**MODIFICATION REQUEST:
FERN BAY SEASIDE VILLAGE
SEASIDE BOULEVARDE, FERN BAY
06_0250 MOD 5**

Director-General's
Environmental Assessment Report
Section 75W of the
Environmental Planning and Assessment Act 1979

April 2014

DRAWING TITLE
STAGING PLAN
DEVELOPMENT
PROJECT PLAN F
FERN BAY SEASIDE VILLAGE
NELSON BAY ROAD, FERN BAY
CLIENT
RAWSON COMMUNITIES PTY LIMITED

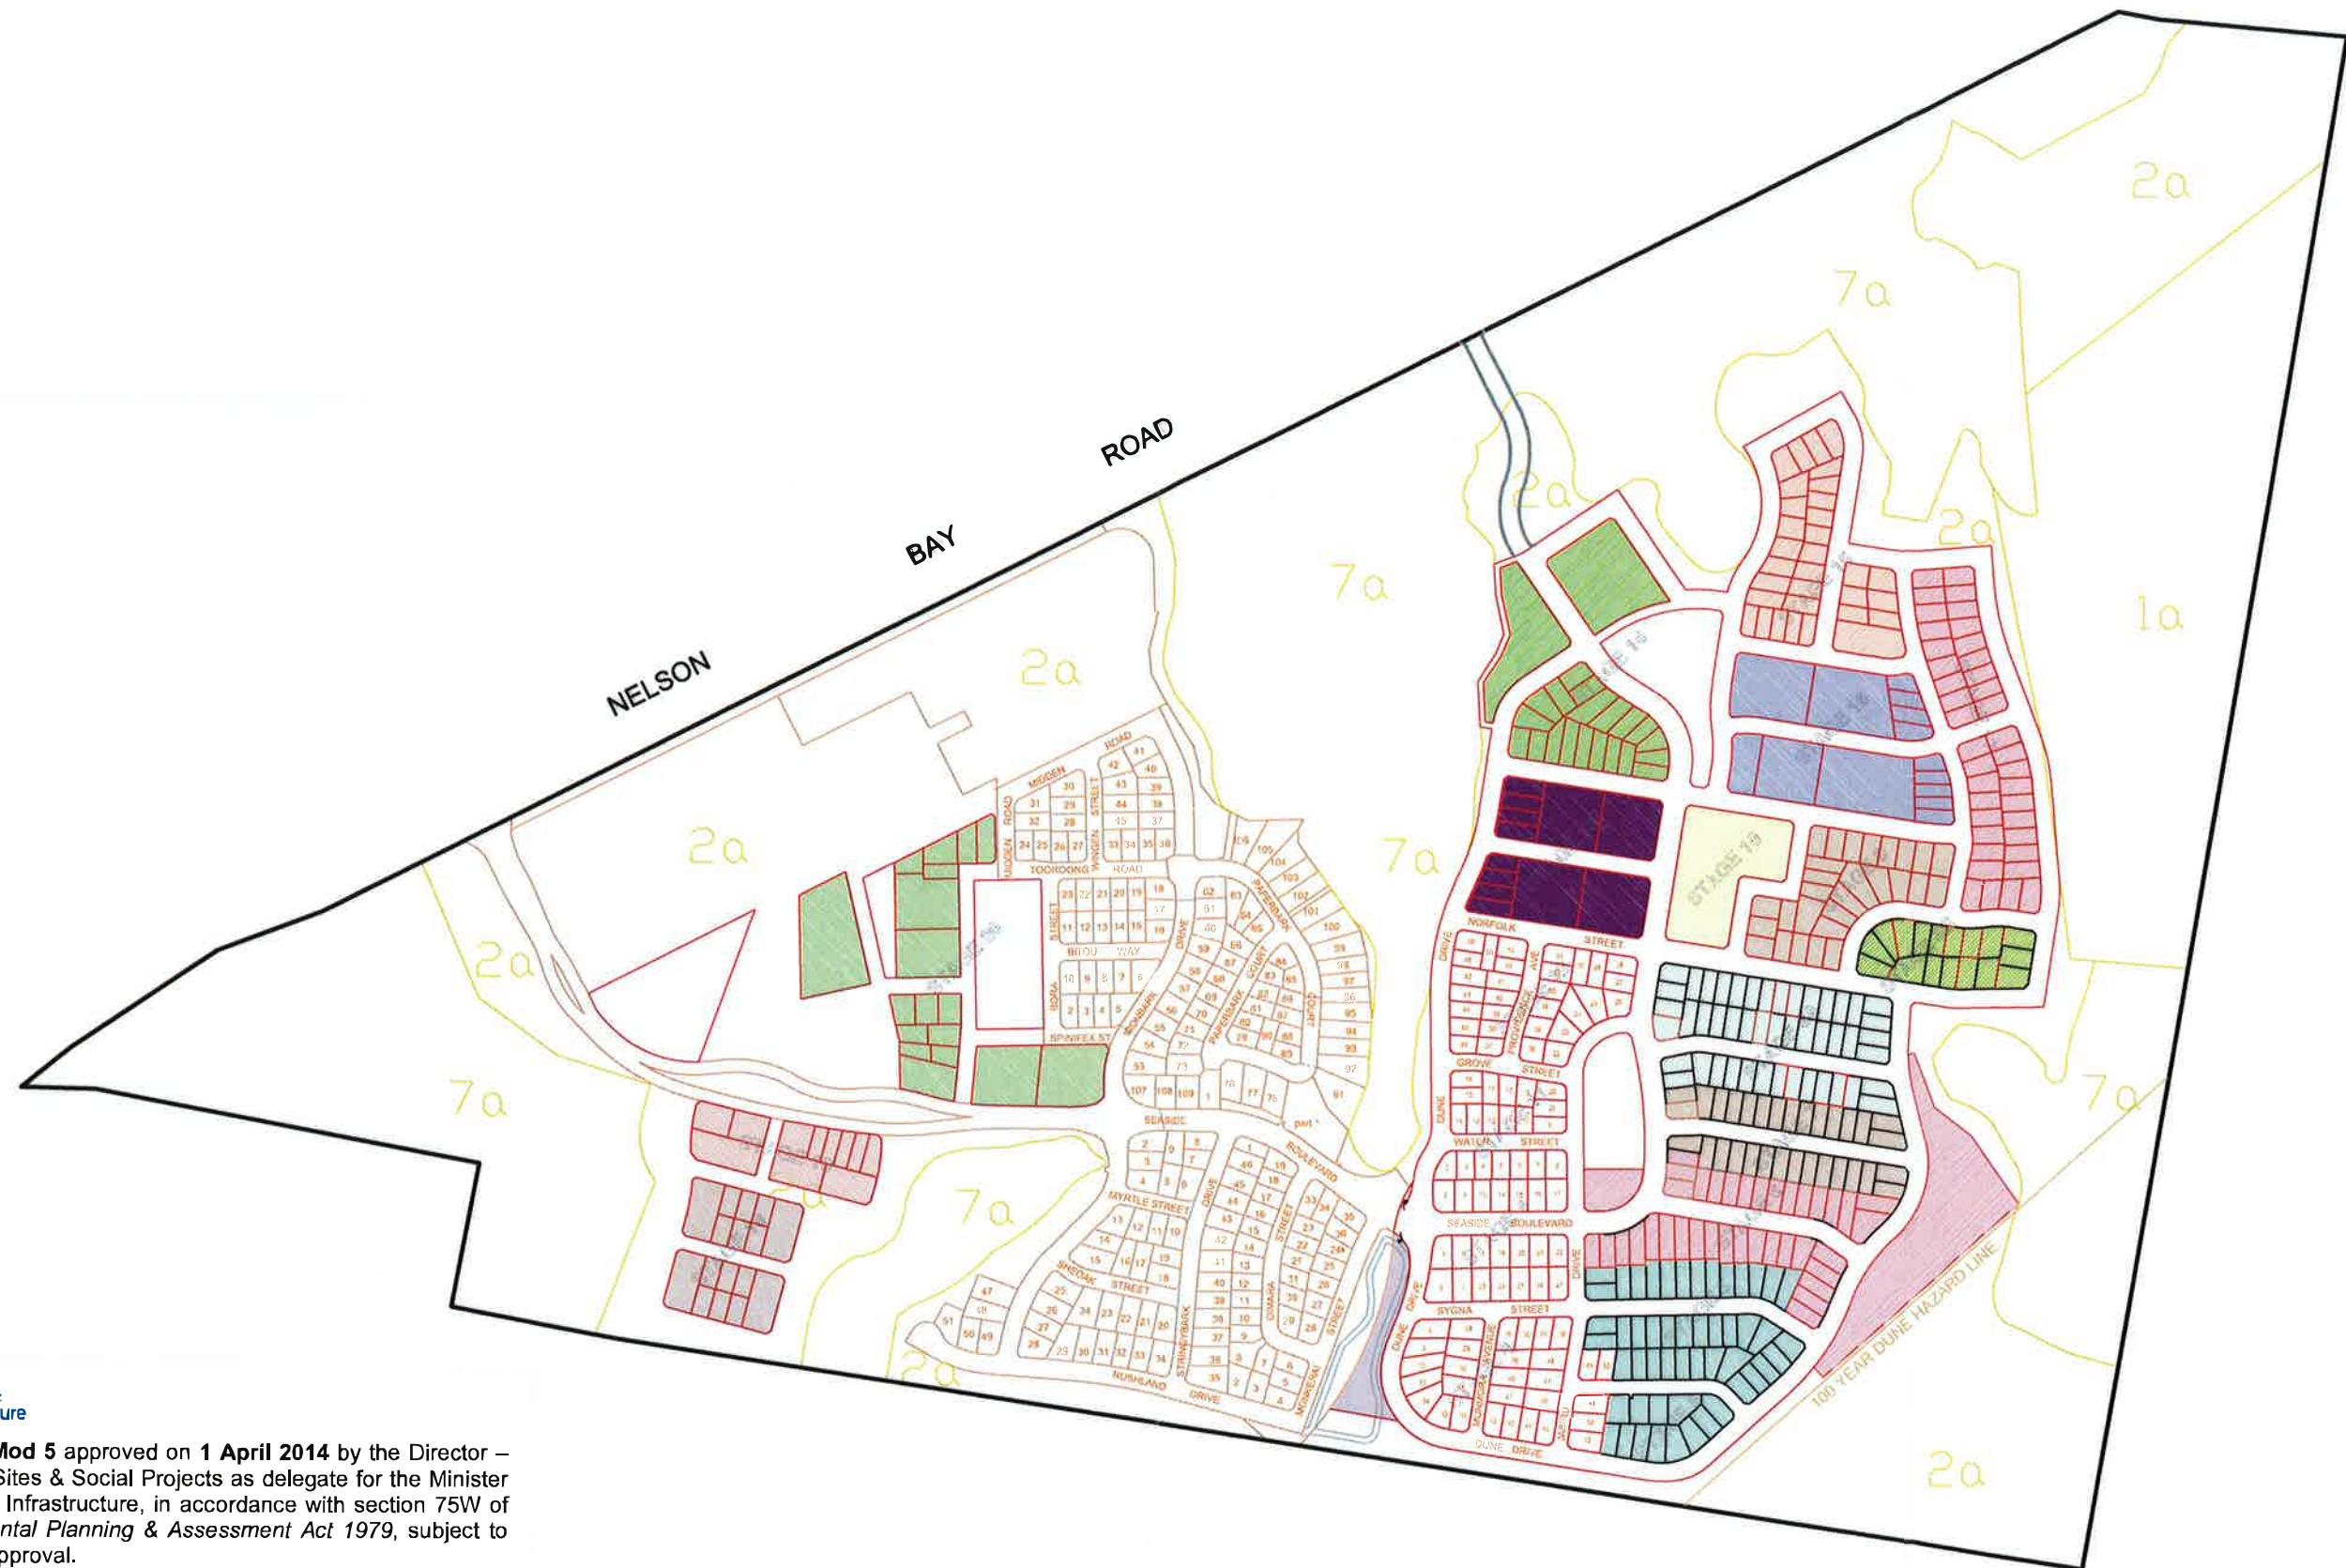
The proponent seeks to develop Stage 8 in two individual stages, to be referred to as Stages 8A and 8B. The modification is sought as the lots approved within Stage 8 are currently spread across separate sewer servicing catchments.

The 47 lots contained within catchment 5 are proposed to be developed as part of new Stage 8A. The remaining 17 lots are within catchment 7 and proposed to be developed as part of new Stage 8B.

The division of Stage 8 into two separate stages is requested in order for future lots to correlate with the relevant sewer servicing catchment. Council did not raise any concern with the proposed modification. The agency also raises no issue with this aspect of the modification request.

The modification seeks to amend the approved stage sequencing, with Stages 6 & 7 proposed to be developed ahead of Stage 5 (**Figure 6** illustrates Stages 5 to 8). The proponent has advised that the commencement of Stage 6 ahead of Stage 5 will allow for the earlier delivery of the approved stormwater detention basin (also shown at **Figure 6**). The proponent considers it logical to then develop the adjoining stages being north to Stage 7 and south to Stage 5. As a result of the amended sequencing of stages, the provision of certain infrastructure and services required as part of the development is also proposed to be amended, including:

- construction of sewer pump station P5 – approved under Stage 5, now proposed within **Stage 6**;
- construction of infiltration basin 6 – approved under Stage 5, now proposed within **Stage 6**;
- construction of unnamed park (R6) including recreation facilities – approved under Stage 5, now proposed within **Stage 6**; and
- construction of the Banksia Park (R4) including recreation facilities – approved under Stage 7, now proposed within new **Stage 8A**.

The requirement to develop stages sequentially was deleted as part of MOD 3, subsequently giving the proponent a degree of flexibility in regards to the timing of construction of future stages. The agency, therefore, raises no concern in regards to the amended sequencing of stages. It is noted that infrastructure and services including sewer pump station P5, the infiltration basin and parkland areas R4 and R6 will be provided as future demand dictates.

STAGES 4 - 6 DETAIL PLAN REV-F

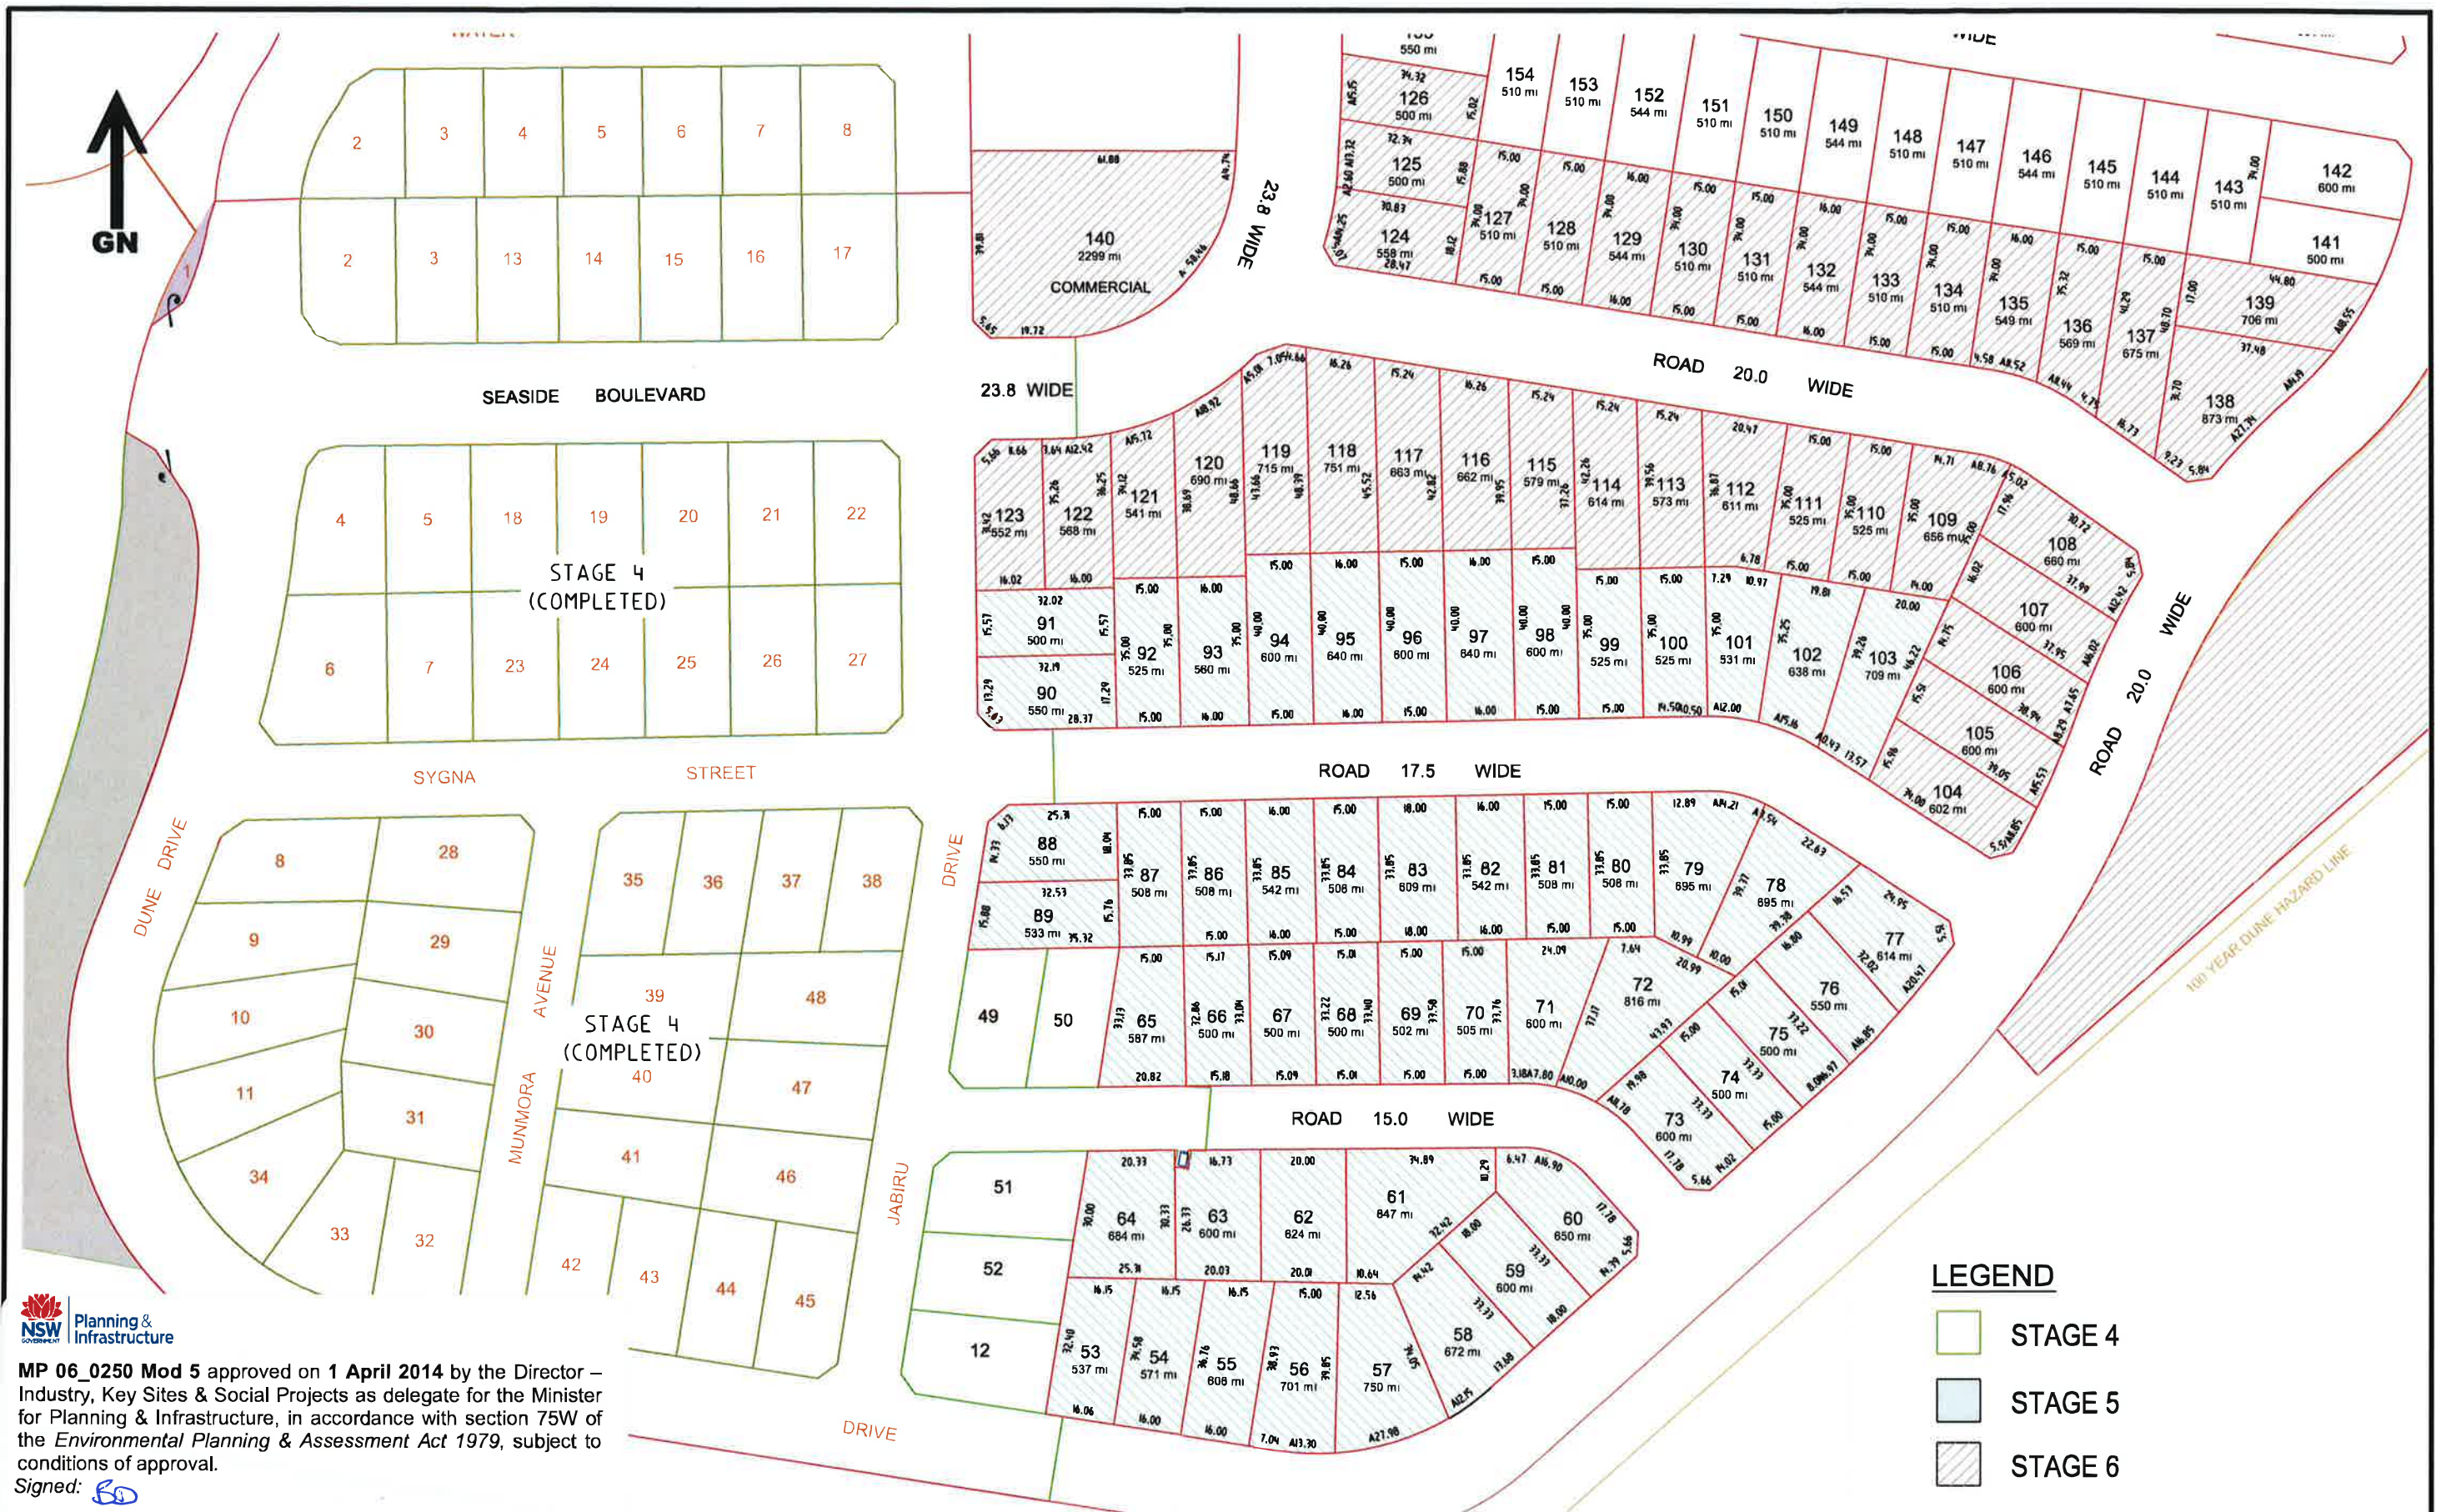
The size and configuration of residential lots approved under Stages 5 to 8 are proposed to be amended slightly. Those lots within Stages 5 & 6 are proposed to be shifted marginally to the north. The proponent advised that the minor variations to the shape of some residential lots will improve the constructability of dwellings on these lots. The proponent further advised the amended subdivision design will provide safer intersection alignments within Stages 5 & 6 from the approved 'Y' intersection configuration to a safer 'T' intersection.

The proposed modification to the subdivision layout does not result in the creation of any additional lots, and the urban footprint will not expand beyond what was originally approved. The revised intersection alignments will also provide for the safer movement of traffic within the subdivision due to improved sight distances. The agency, therefore, raises no concern in regards to this aspect of the modification.
